**Greensquare Homes Limited Former Bodicote
Farm White Post Road Bodicote Banbury OX15
4BN**

21/01857/DISC

Proposal: Discharge of Condition 10 (Construction Environmental Management Plan) 14 (Archaeology) of 18/00792/OUT - Appeal reference: APP/C3105/W/19/3222428

Project		
BODICOTE Near Banbury		
Drawing Title		
Site Safety Logistics Plan		
File Location: S:\TEAM ASSET MANAGEMENT\2019 PROJECTS		
Date	Status	
16/11/2020	Provisional	
Scale	Drawn by	Checked by
1:500 @ A1	MS	-
Project No.	Drawing No.	Revision
22-029	C/SL/115	/ C

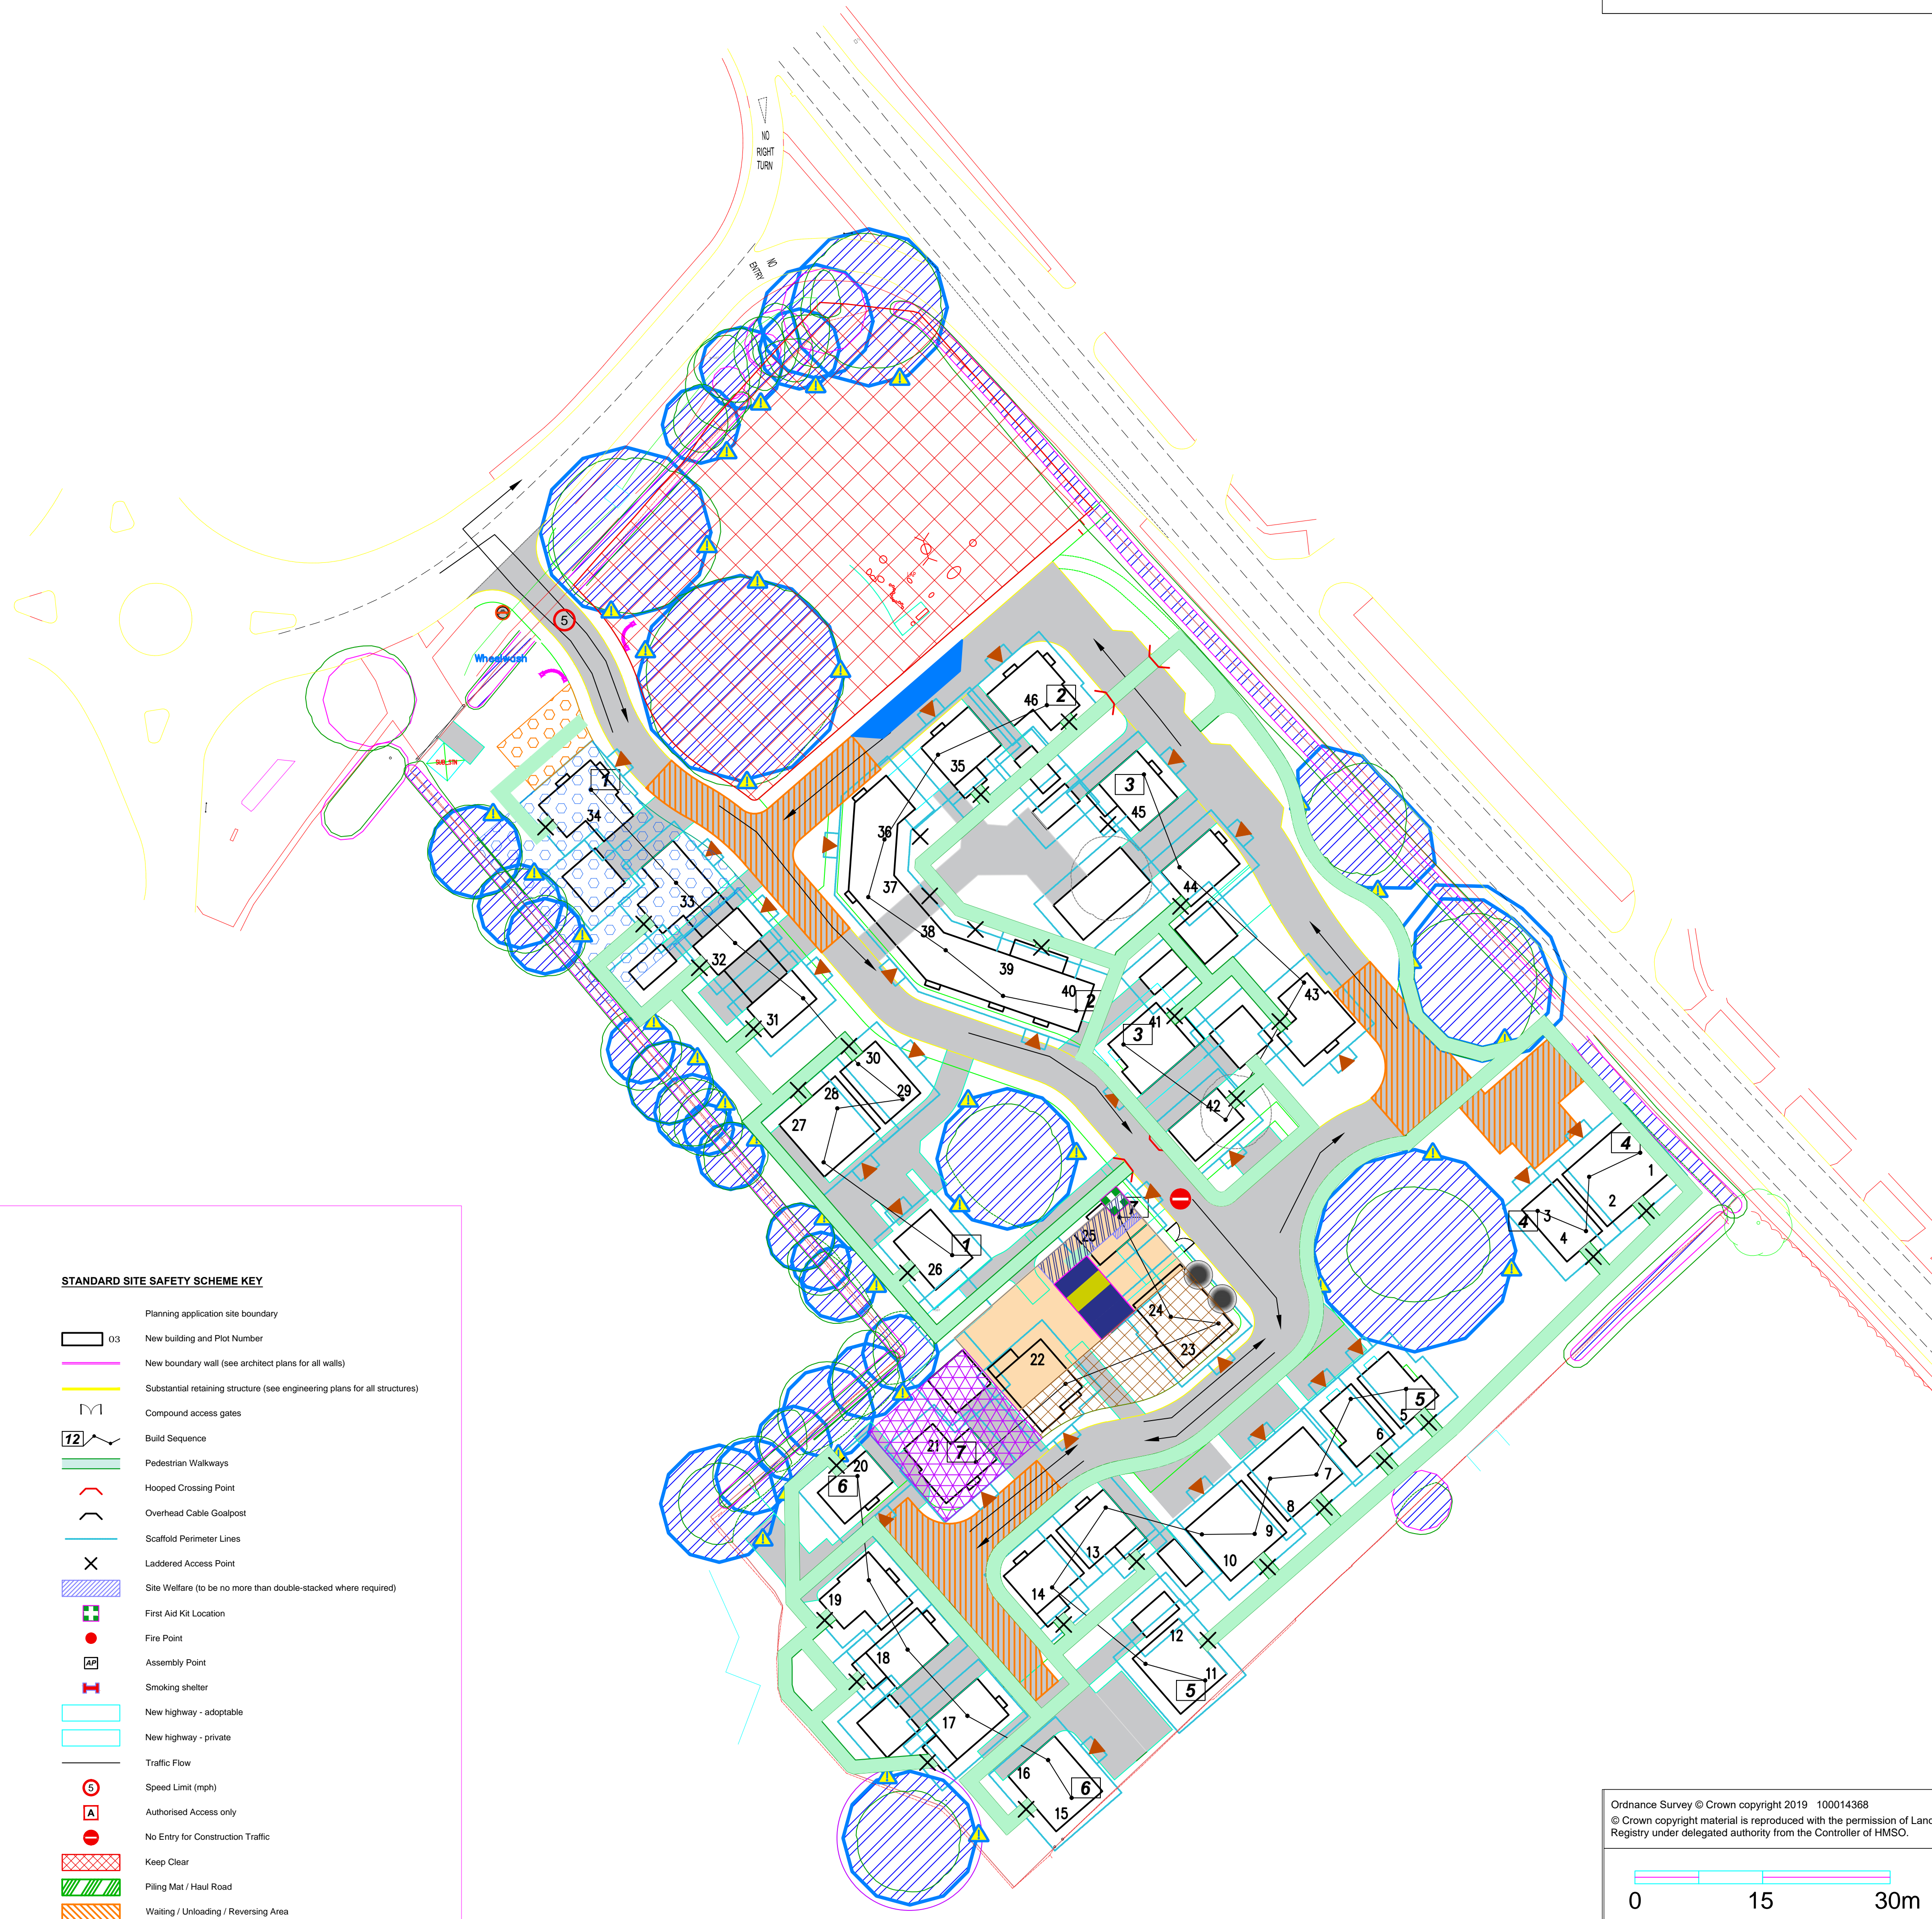
- 5.2. OCC Transport – Objection to discharge of condition 10 (requiring amendment of CEMP).

- 5.4. CDC Environmental Health – No objection to CEMP Statement but the hours of work on the Construction Environmental Management Plan should match those in the Statement.

- 6.1. Condition 10 – The original CEMP and Method Statement submitted with this application was not considered acceptable by OCC Transport or Environmental Health. The original Site Safety and Logistics Plan drawing number 0737-115A did not show Contractor Parking and the permitted traffic routes were not shown on a marked-up plan. The Environmental Health Officer wished to see the hours of work on the CEMP plan match those in the accompanying CEMP Statement. The amended CEMP and Method Statement has addressed the concerns raised and both OCC Transport and Environmental Health raise no objection to the revised documents. The condition can therefore be discharged accordingly.

Update: 6th October – no objection (following receipt of amended CEMP).

Update: 28th September 2022 – no objection to amended CEMP.

CEMP Rev 4 dated September 2022 produced by Focus Environmental Consultants and Construction Environmental Method Statement Rev C dated September 2022 and Site Safety Logistics Plan drawing number C/SL/115 Rev C.
